## 1.0 Landscape

This response is made with primary reference to document AP-044 3.1.32 Environmental Statement Chapter 30 Landscape and Visual Impact Assessment, and documents AP-083 to AP-088, 3.2.26 Environmental Statement Chapter 30, Figures Part 1 to 6.

The key elements of North Falls project include the proposed Offshore Wind Farm, the Onshore Substation (OnSS), onshore Export Cable Corridor (onshore ECC) and the landfall (where the offshore export cables will meet the onshore export cables).

# **Onshore Substation Zone of Theoretical Visibility and Viewpoint Locations with Dedham Vale National Landscape**

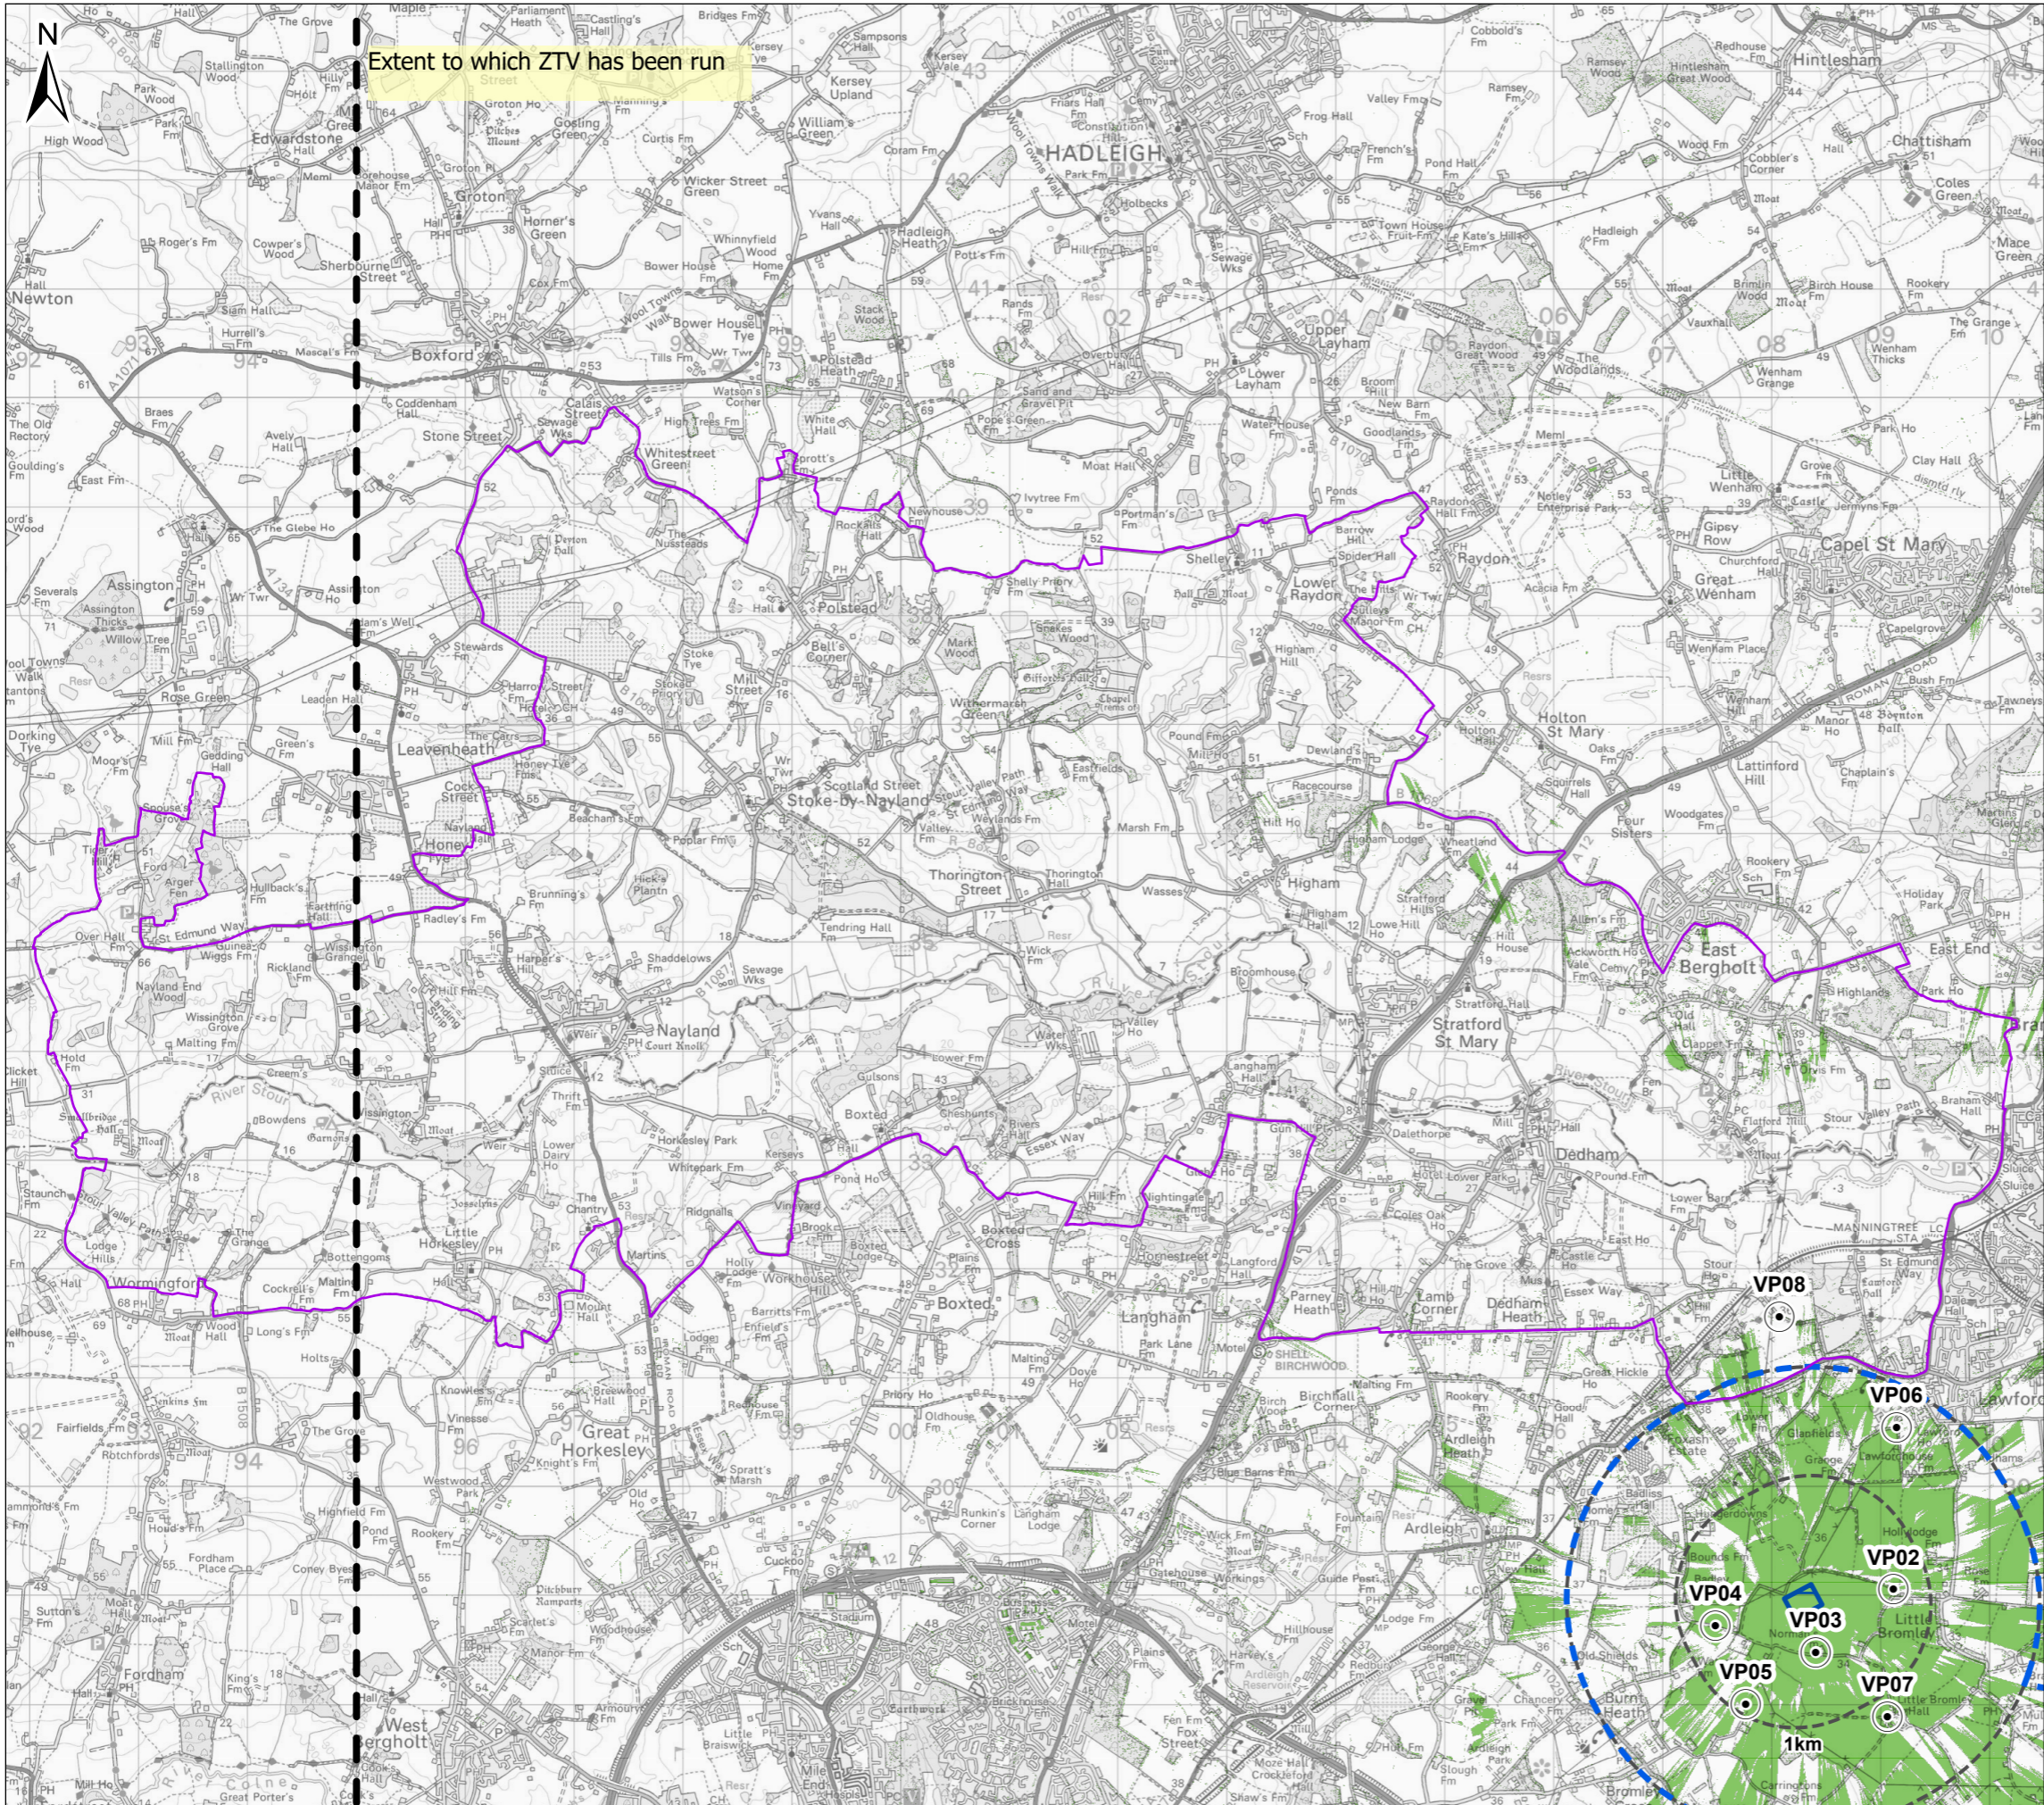
We are concerned that there is only one viewpoint VP No8 that is taken from the Dedham Vale National Landscape and that is at a substantial distance from the development when other areas of theoretical visibility are closer. It is not clear whether other viewpoints within the National Landscape or its setting were explored or whether the enhanced duty under LURA 2023 has been addressed. A figure should be provided combining the viewpoints with the ZTV and National Landscape boundaries, to make understanding of their relationship easier. We propose additional viewpoints are required to demonstrate that there are no significant impacts on the National Landscapes and their settings. Closer viewpoints and visualisations have been made available by the Five Estuaries applicant.

1 New visualisation (VP9) from Barn Lane - Grange Road

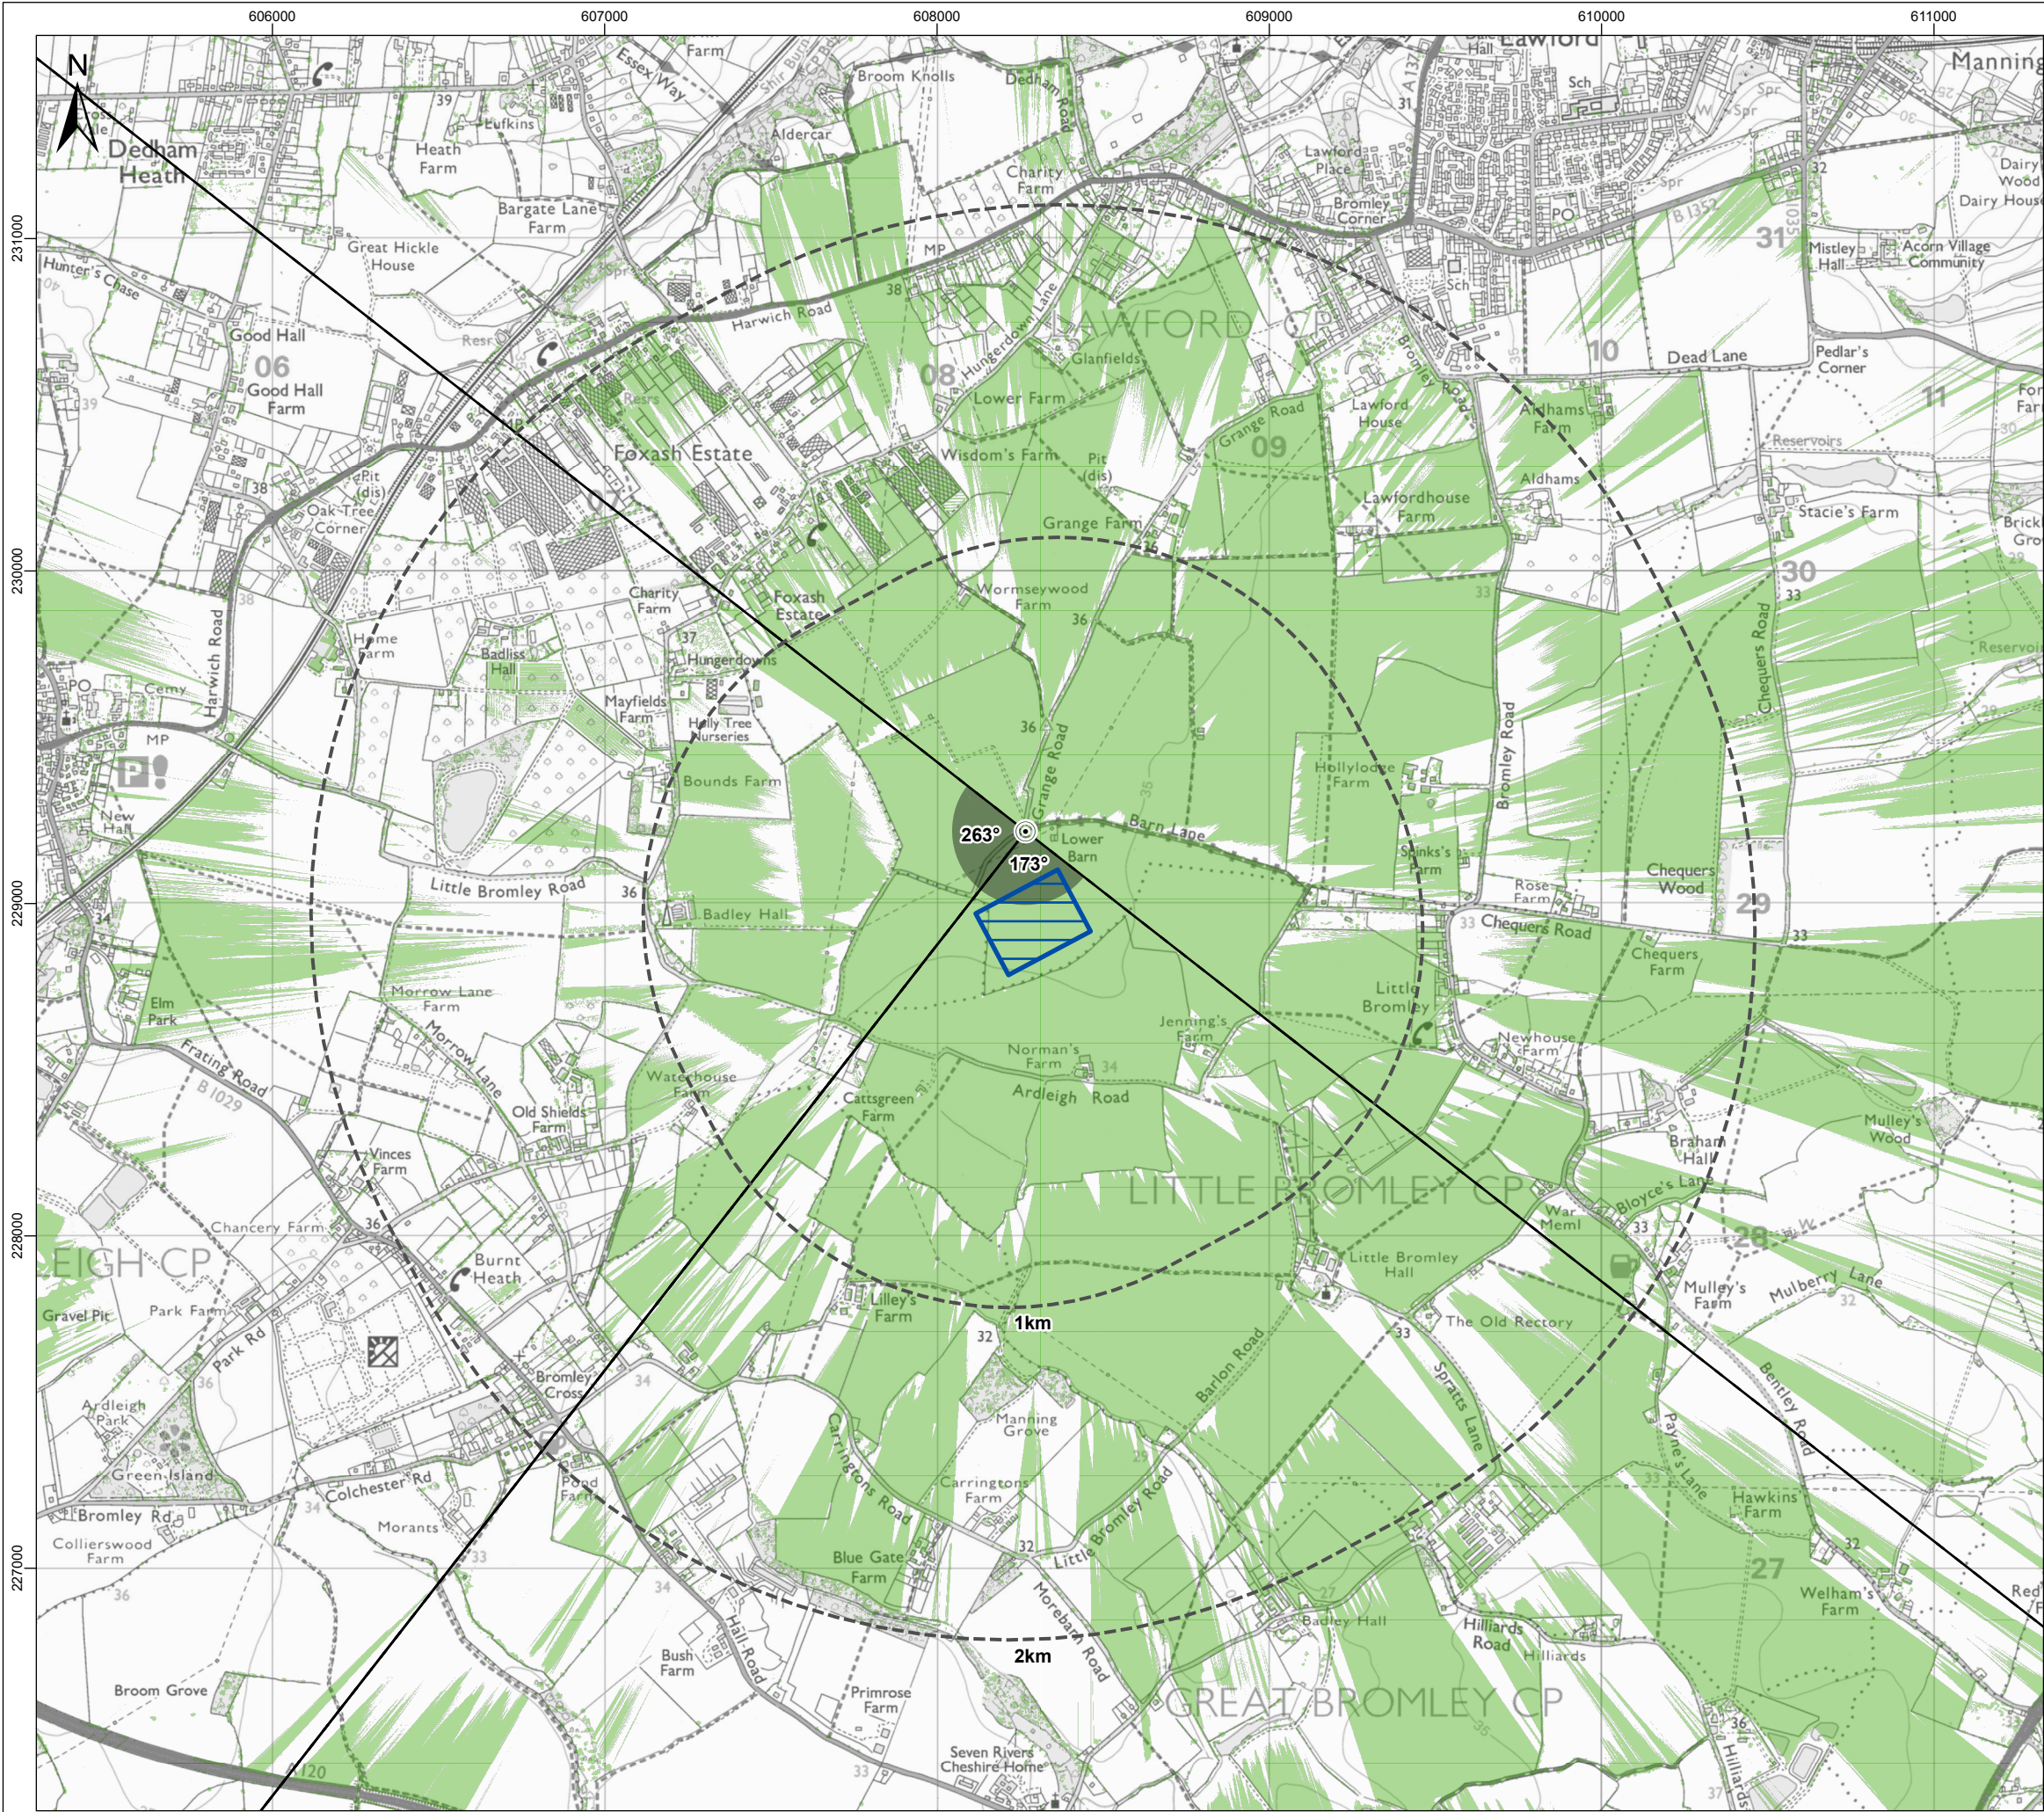
It is unclear why no viewpoints have been taken from Grange Road to the west/north-west of the site when there are open views along much of the eastern boundary and the proposed facility lies closest to it. There appear to be no viewpoints to the north-west of the site within the study area at all, despite there being several PRow as well in this direction. At least two viewpoints are needed along Grange Road close to the site. This is also the boundary around which the least mitigation is possible increasing the likelihood of significant impacts from this direction. Despite its name, Grange Road is a narrow lane at this point, characteristic of this landscape and so receptors using it should be assessed appropriately. VP6 is over 1.5km away so likely impacts judged from that distance are likely limited.
